**Application for a non-material amendment following a grant of planning permission,
Town and Country Planning Act 1990**

**Non-material amendment to previous permission ref: 2019/91569 for erection of 31
dwellings at land south-east of Abbey Road, Shepley, Huddersfield, HD8 8FG**

Application Number: 2021/90819

HOUSE TYPE C2 - PLOTS 4 & 31
1914-HT-C2-01 REV. D
ABBAY ROAD, SHEPLEY
YORKSHIRE COUNTRY PROPERTIES
SCALE:1:100@A3 - MAY 2019

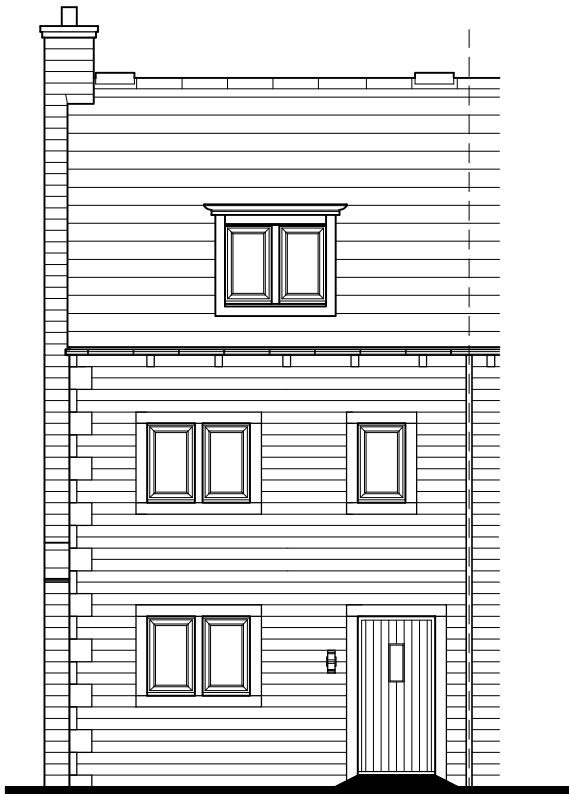
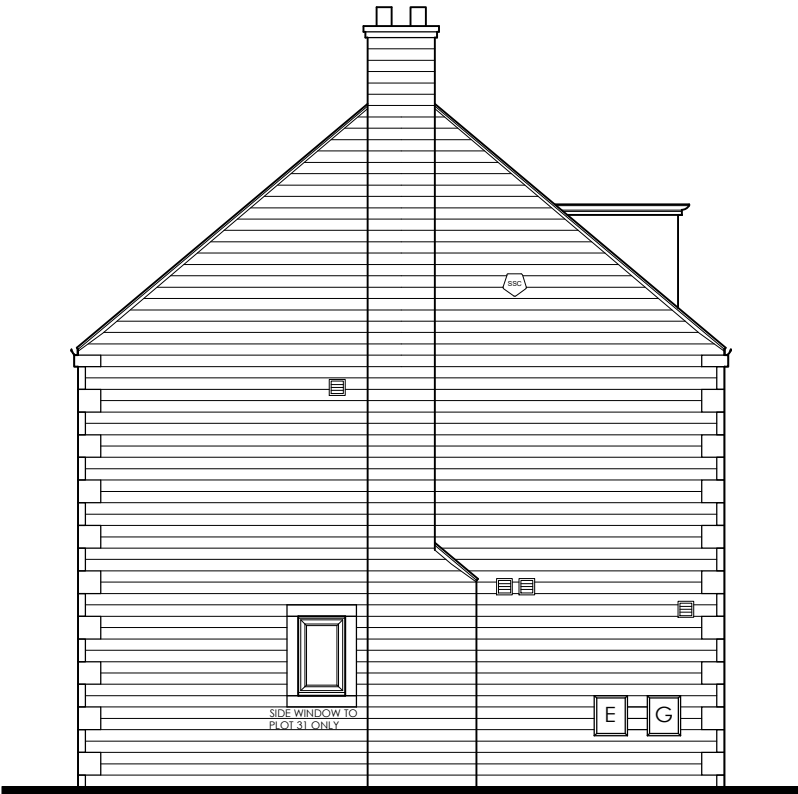
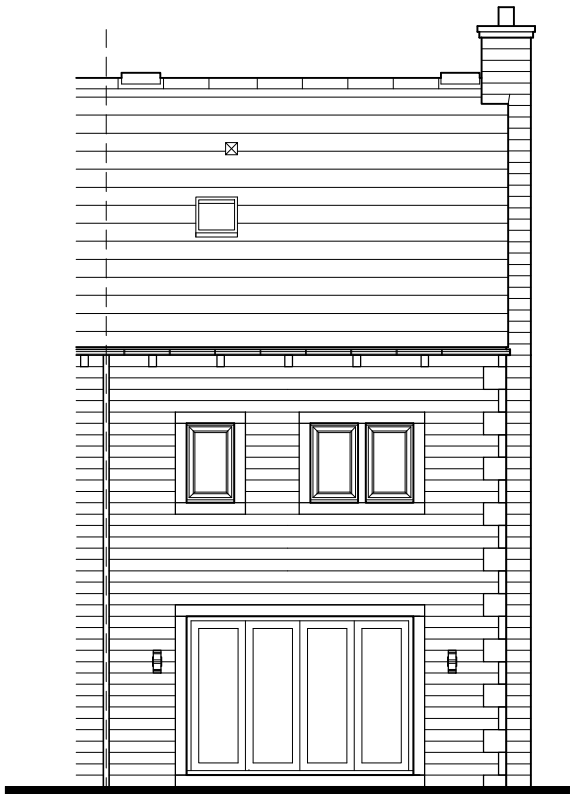
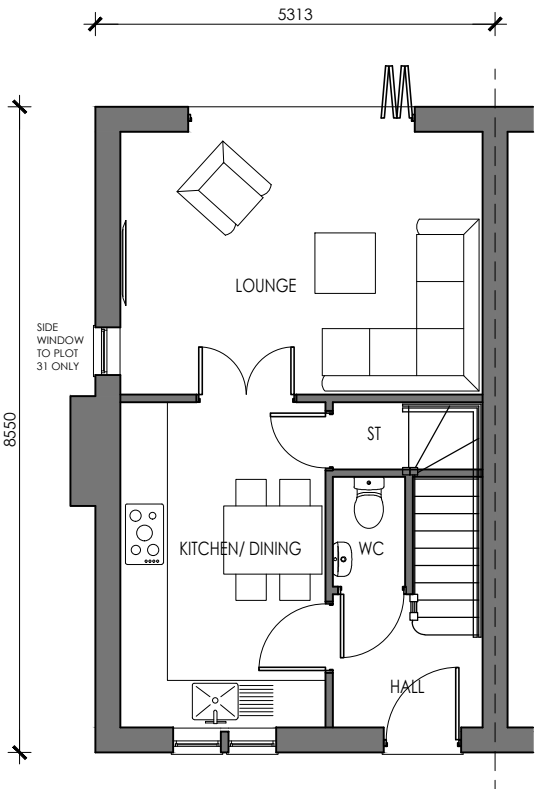
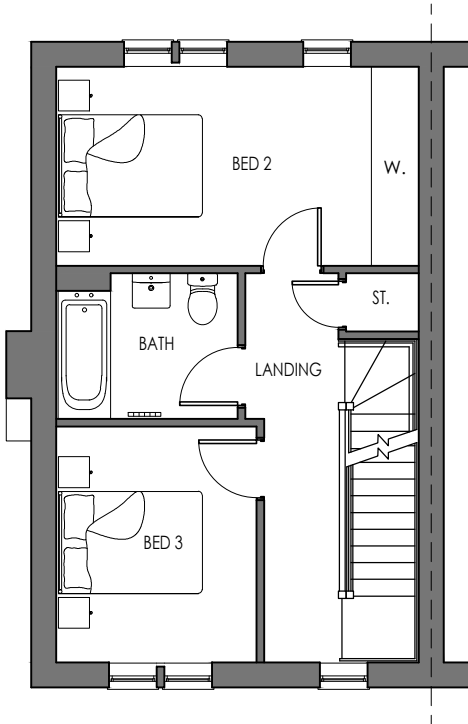
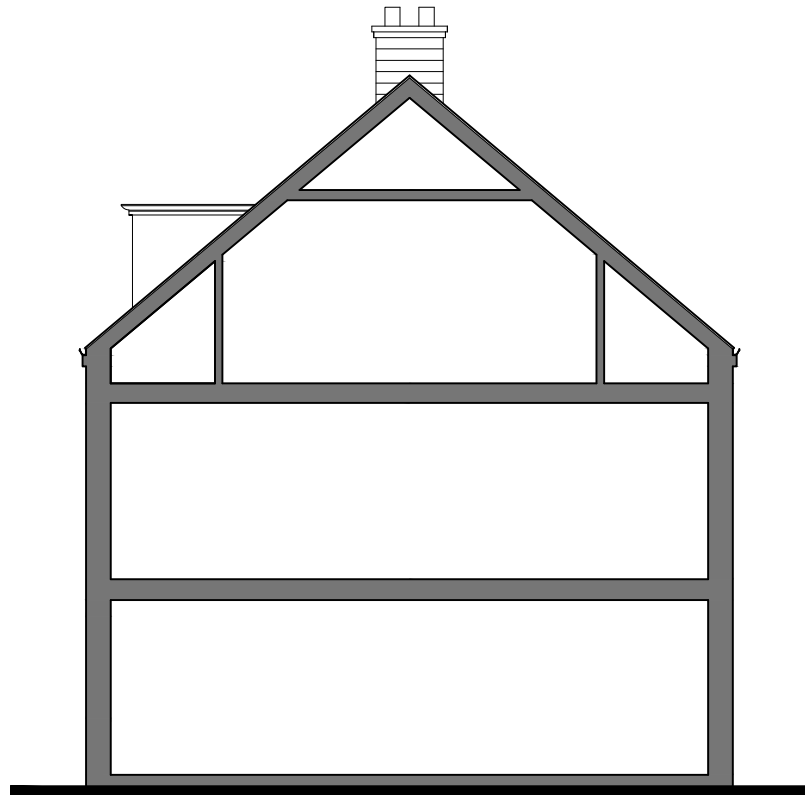
- Window at front elevation (ground floor level) reduced from three lights to two (units 3, 4, 14, 15, 29, 30 and 31).
- Window and French doors at rear elevation (ground floor level) replaced with folding doors (units 3, 4, 14, 15, 29, 30 and 31).
- Ground floor window deleted from side elevation (units 3, 14, 15, 29 and 30).
- Ground floor window relocated along side elevation (units 4 and 31).
- Projecting side elevation chimney deleted (units 3, 14, 15, 29 and 30).
- Meter boxes, alarm box, vents and external lighting shown on elevations (units 3, 4, 14, 15, 29, 30 and 31).
- Coping and kneelers added to gable ends (units 14 and 15).

- 1914-HT-C2-01 rev D (plans and elevations for units 4 and 31).
- 1914-HT-C2-02 rev B (plans and elevations for units 14 and 15).
- 1914-HT-C2-03 rev A (plans and elevations for units 3, 29 and 30).

I confirm that the alterations are acceptable and may be considered as a non-material amendment to the approved drawings. It should be noted that this letter relates only to the non-material amendment sought and it is not a re-issue of the original planning permission. The two documents should be read together and as such, all conditions imposed on the original granting of planning permission apply to the proposal as now amended. A copy of this letter and the amended plans will be retained on the public record of approved documents.
